Historic England

**PRICKLEDEN MILLS, WOODHEAD ROAD, HOLMFIRTH, HUDDERSFIELD, WEST
YORKSHIRE HD9 2JU**

Application No. 2023/91491

Thank you for consulting us on the amended plans for the proposed residential development on the former Prickleden Mills site.

**PROPOSED SITE SECTIONS SHEET 1 OF 2**

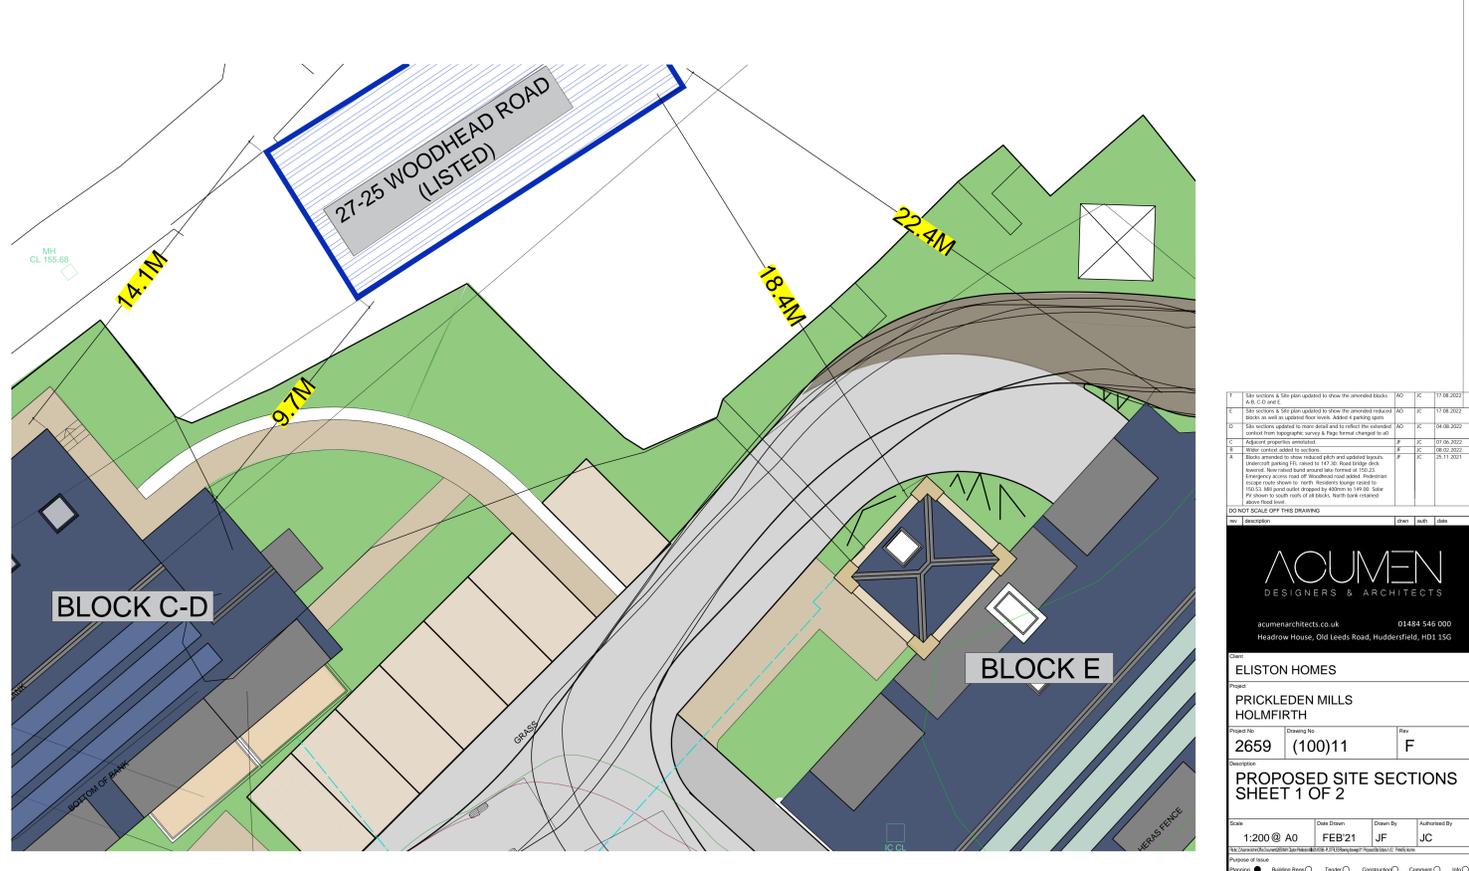
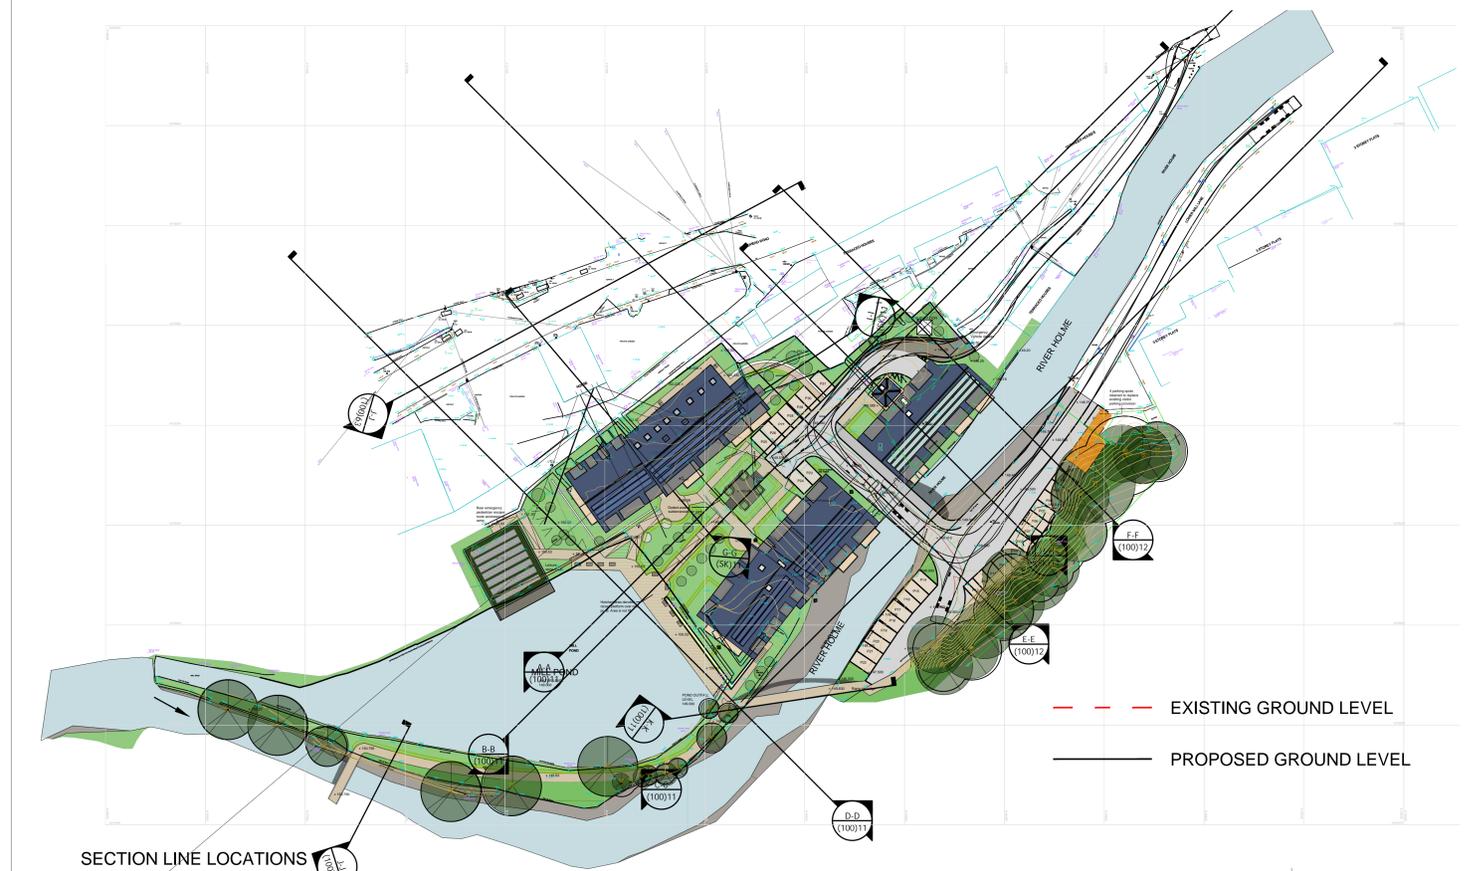
In our letter of 20th November 2023 we raised concerns relating mostly to the scale of block C-D. The amended plans show no or little change in terms of this scale and so we would ask that the concerns raised in our previous letter relating specifically to the proposed scale of block C-D are considered whilst determining this application.
